City of Portland, Maine - Building or Use Permit Application
 389 Congress Street, 04101 Tel: (207) 874-8703, Fax: (207) 874-8716

Permit No: 03-0235	Issue Date: MAY 06 2003	CBL: 087 00017001
-----------------------	-----------------------------------	----------------------

Proposed Use: Single Family	Proposed Project Description: Construct One Story 10'x14' Addition
---------------------------------------	--

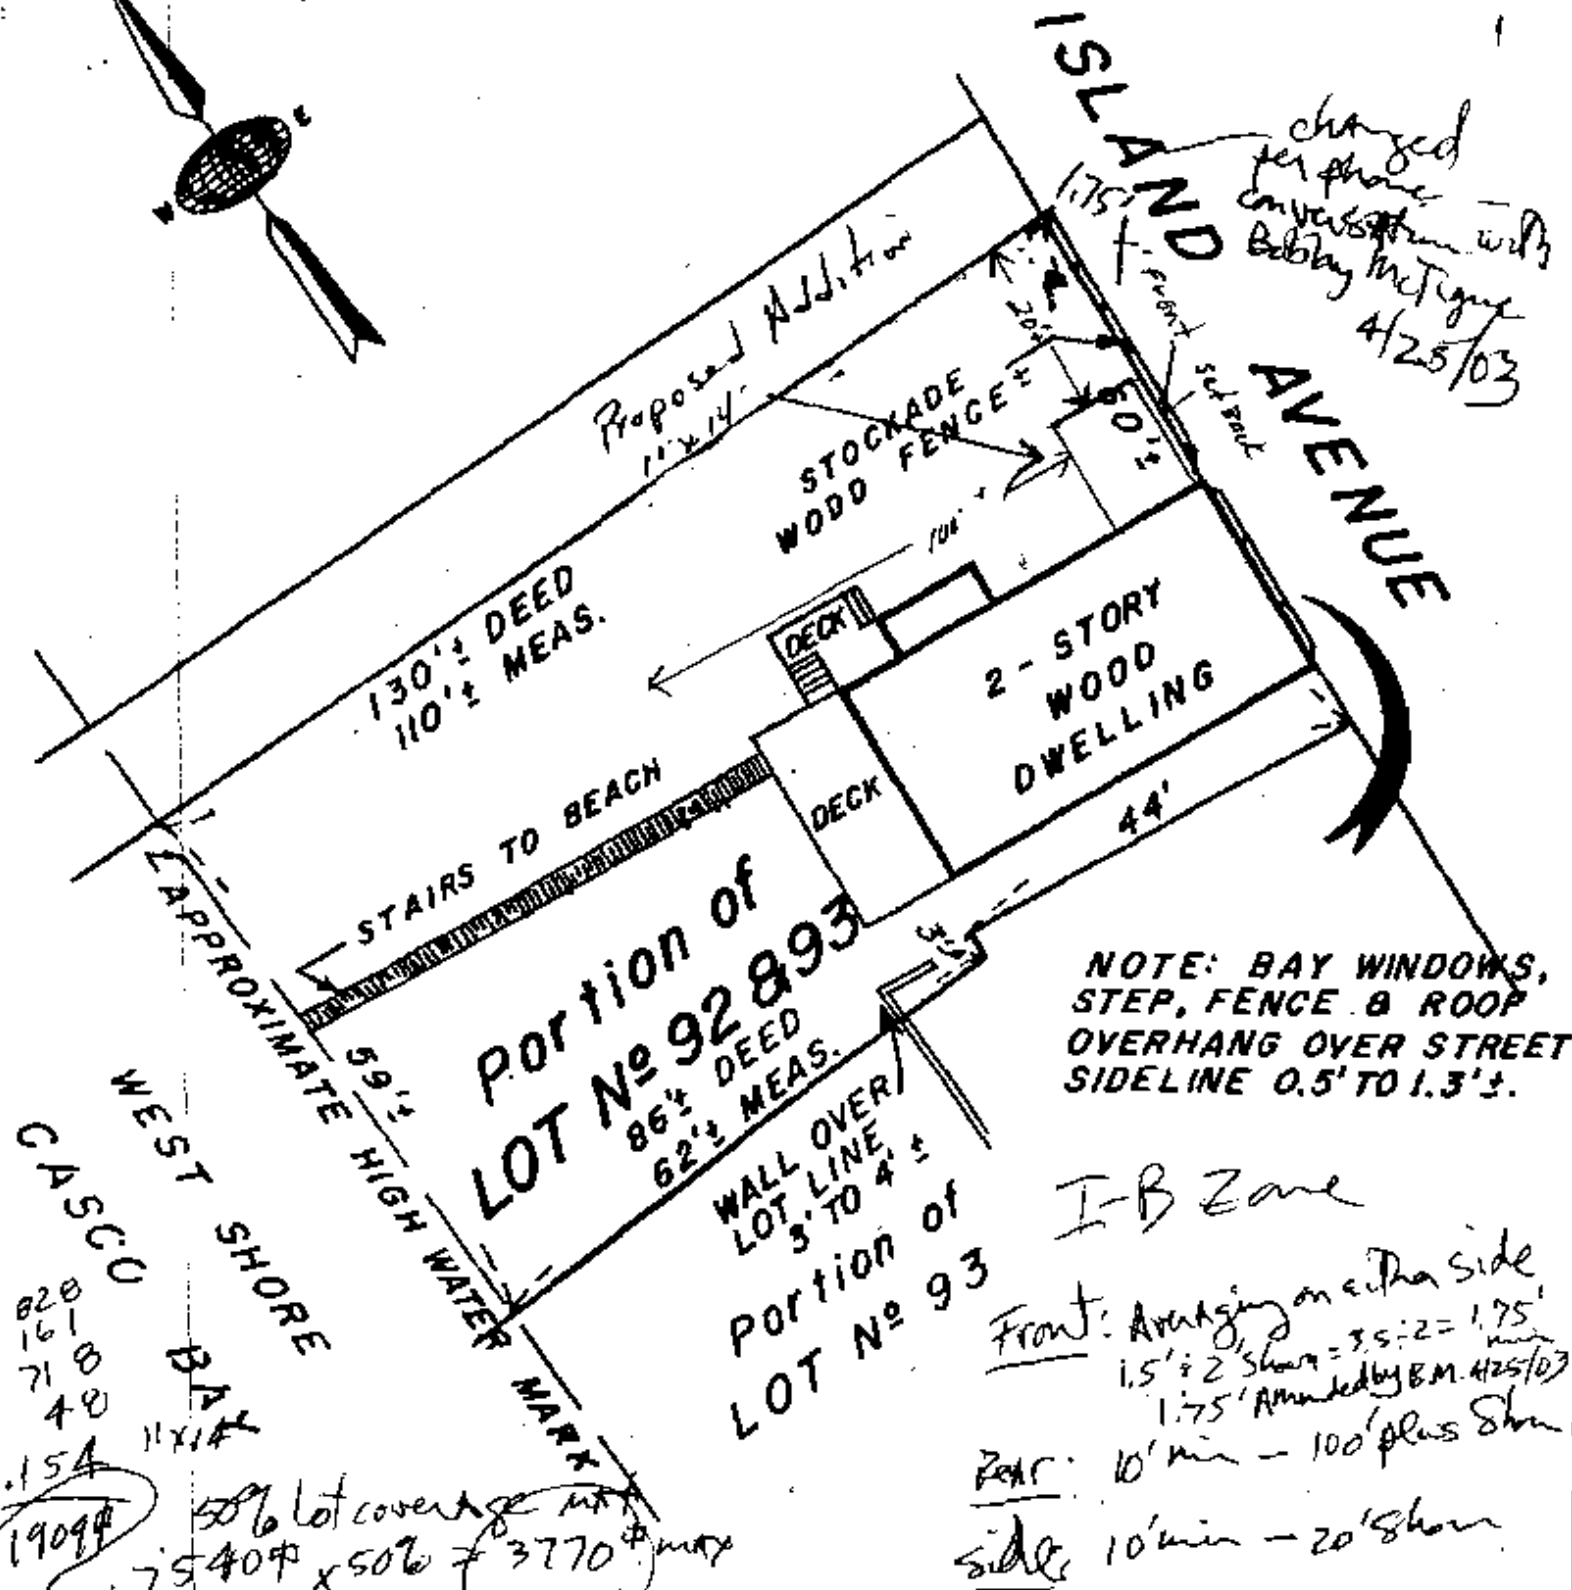
Note: 4/25/03 the I-B zone allows for averaging the front setback which would be 1.75' - only 1 foot is shown. I left a message for Bobby McTigue to call me back on this 4/25 - B. Mctigue told me verbally that he will meet the 1.75' minimum setback. This permit is issued subject to this statement **Ok to Issue:**

- 1) This permit is being issued with the understanding that the minimum allowable front setback (based on averaging) is 1.75 feet. The contractor stated that he would meet this setback. PLEASE NOTE: all required setbacks are to be from PROPERTY LINES; not from street lines - not from sidewalks - not from fences - not from curb lines. The owner/developer/contractor is responsible for knowing where the actual property lot lines are located. You shall be responsible for calling the code enforcement officer PRIOR to any placement of concrete so that the required setbacks can be checked.

## CROSS SECTION

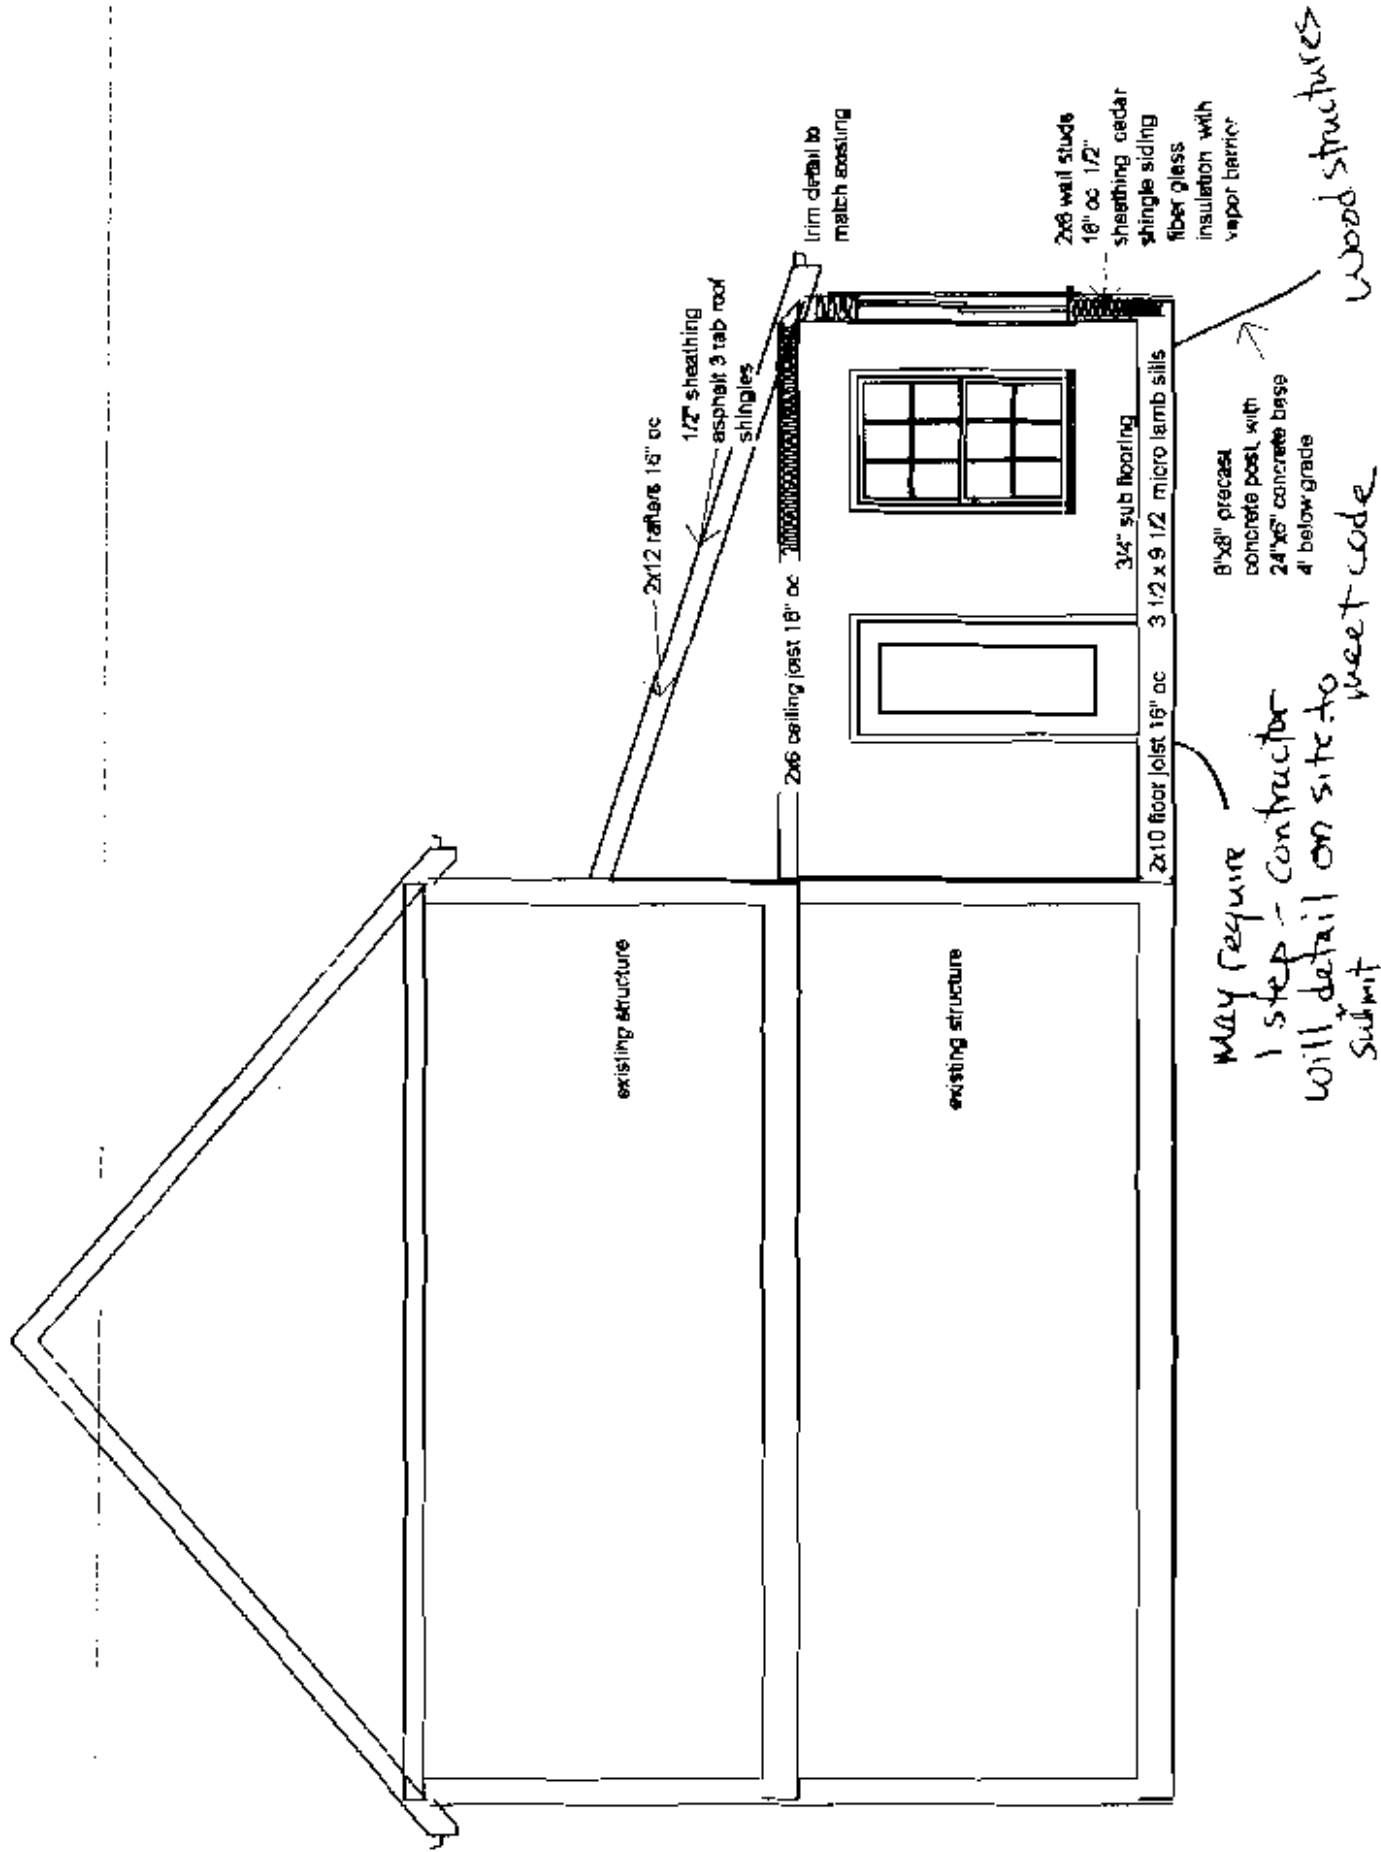
Note: 5/1/02 left msg. At home for R. McTigue to call. Need info on door elevation (?stairs), spec on laminated beam & fasteners to piers. **Ok to Issue:**

- 1) The contractor will have the design load spec on the microlam faxed to us
- 2) Separate permits are required for any electrical or plumbing work.
